CITY OF ALBUQUERQUE

**Re: Private Garage for A & E Auto Sales, 2945 Broadway Boulevard SE,
Grading and Drainage Plan
Engineer's Stamp dated 5-15-05 (M14-D1A)**

**RE: PRIVATE GARAGE FOR A & E AUTO SALES @ 2945 BROADWAY S.E.
(M14-D1A)**

**Re: Private Garage for A & E Auto Sales, 2945 Broadway Boulevard SE,
Grading and Drainage Plan
Engineer's Stamp dated 4-17-05 (M14-D1A)**

GRADING/DRAINAGE PLAN 1" = 20'

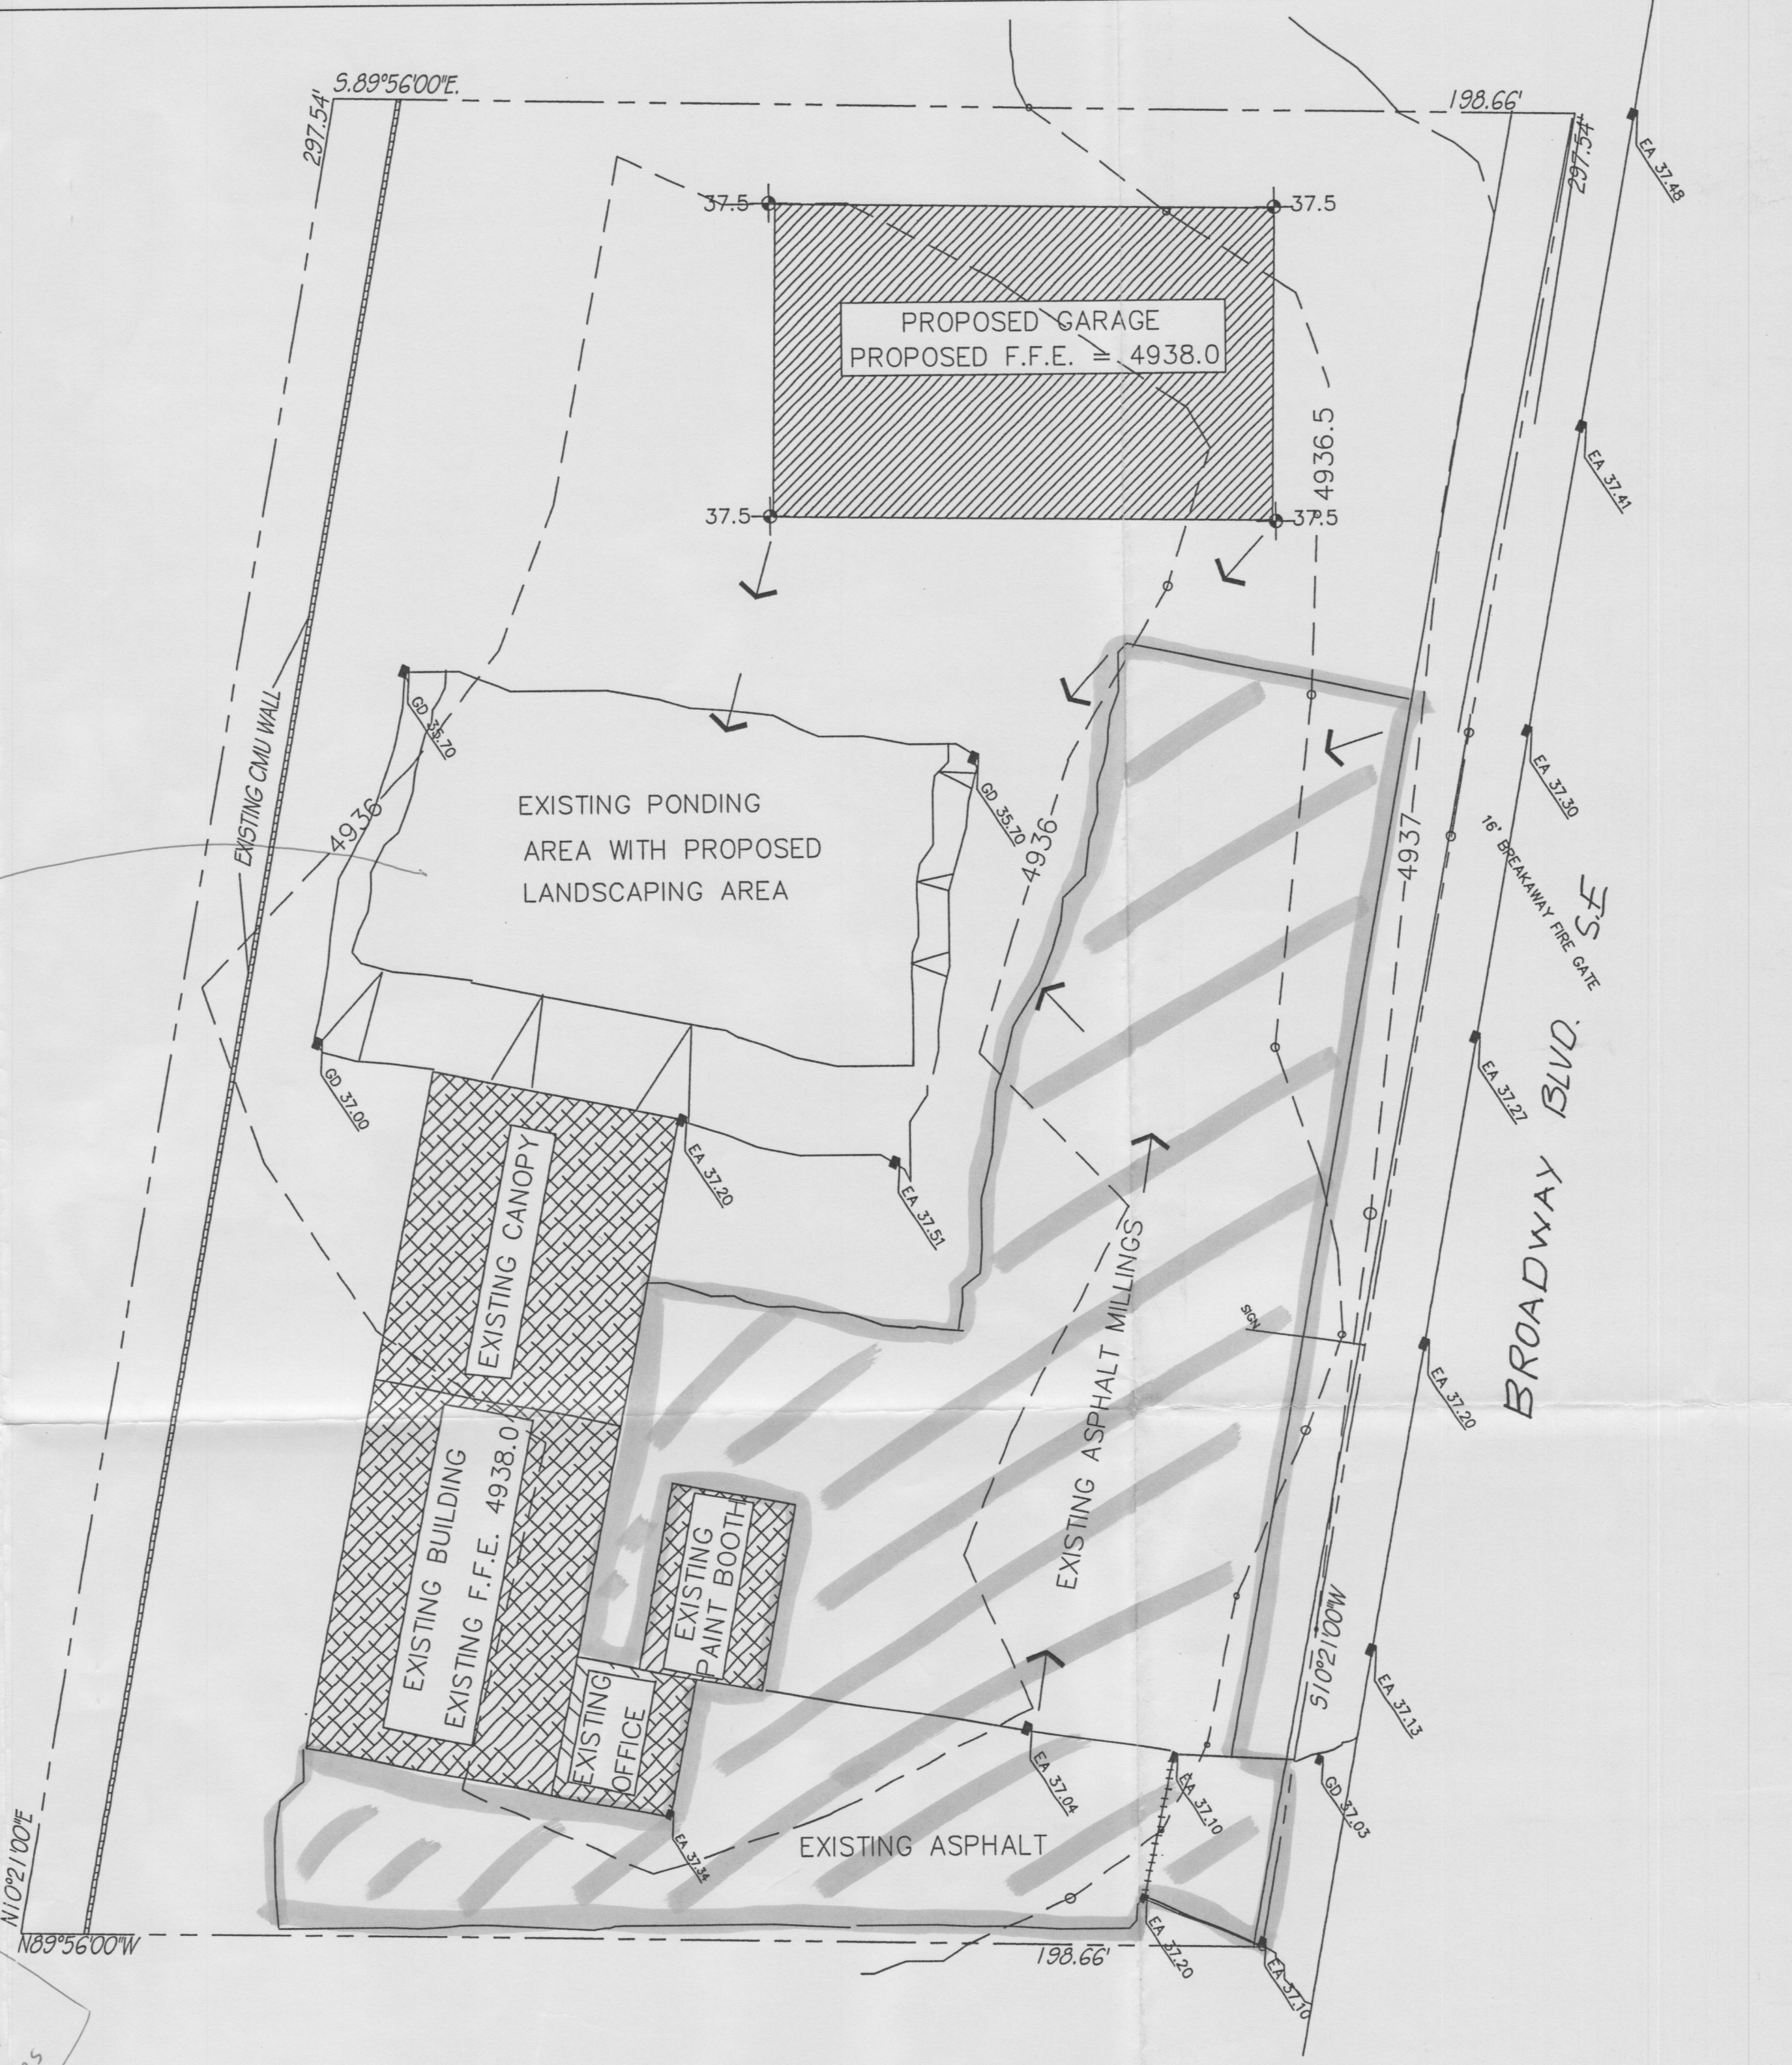
1. According to your calculations and write up, approximately 6400 square feet of landscaping will be added to this site. Please show the location of this additional landscaping.
2. Calculations and details, including the volume required / provided and water surface elevation, must be provided for the pond.
3. The existing contour lines indicate flow entering the site from the northern lot. How is this flow prevented from entering the site?

1. According to your calculations and write up, approximately 6400 sq. ft. of landscaping will be added to this site. Please show the location of this additional landscaping. *I have included a copy of the landscaping plan for your information.*
2. Calculations and details, including the volume required / provided and the water surface elevation, must be provided for the pond. *The pond volume calculations are provided within the plan drawing along with the 100-year water surface elevation*
3. The existing contour lines indicate flow entering the site from the northern lot. How is this flow prevented from entering the site? *Additional spot elevations have been obtained and indicated on the plan drawing. The lot to the north is lower.*
